My reference: 3/2026/0313

Location: Springwood Drive, Whalley, BB7 9XL, Phase 2, Lawsonsteads.

Proposal: Approval of details reserved by conditions 4 (POS timings), 9 (Buffer landscaping), 13 (car charging points), and 15 (water mains protection) on planning permission 3/2021/0760.

AA7403C Clitheroe Road Whalley
 Site Z3 - Proposed Plan (with Car Charging)
 Plots 118 - 188

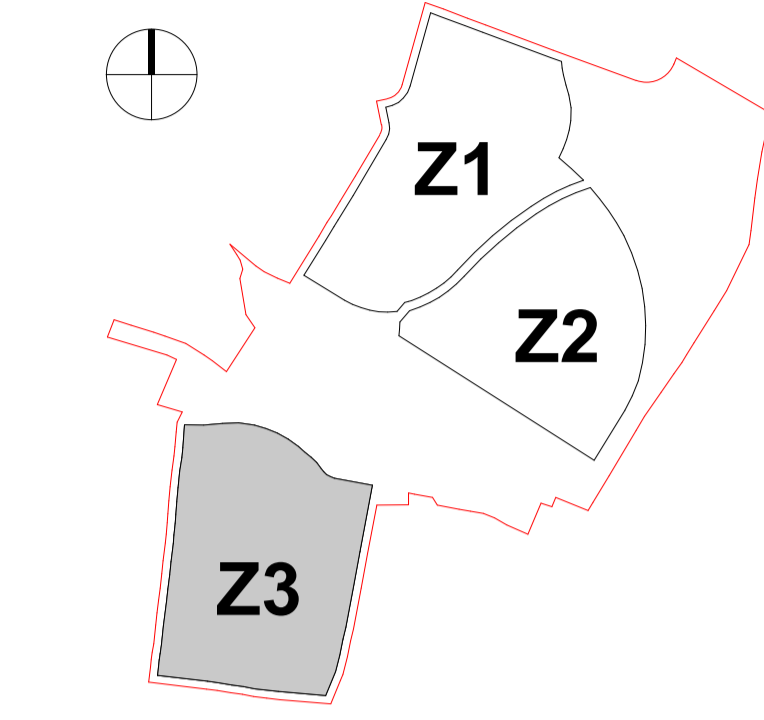
Condition 13 (car charging points) is partially discharged insofar that the submitted details are considered acceptable as follows:

- Site Z3 – Proposed Plan (with Car Charging) Plots 118 – 188 (dwg no. 03099 Rev I)

However, this condition can only be partially discharged at this stage insofar that it also requires details of the car charging points for the plots in Phase 2 of the development which were the subject of planning permission 3/2021/0760.

Furthermore, in respect to the approved car charging point details, the condition can only be partially discharged insofar that it requires the electric vehicle charging points to be installed prior to the first occupation of each dwelling and thereafter retained.
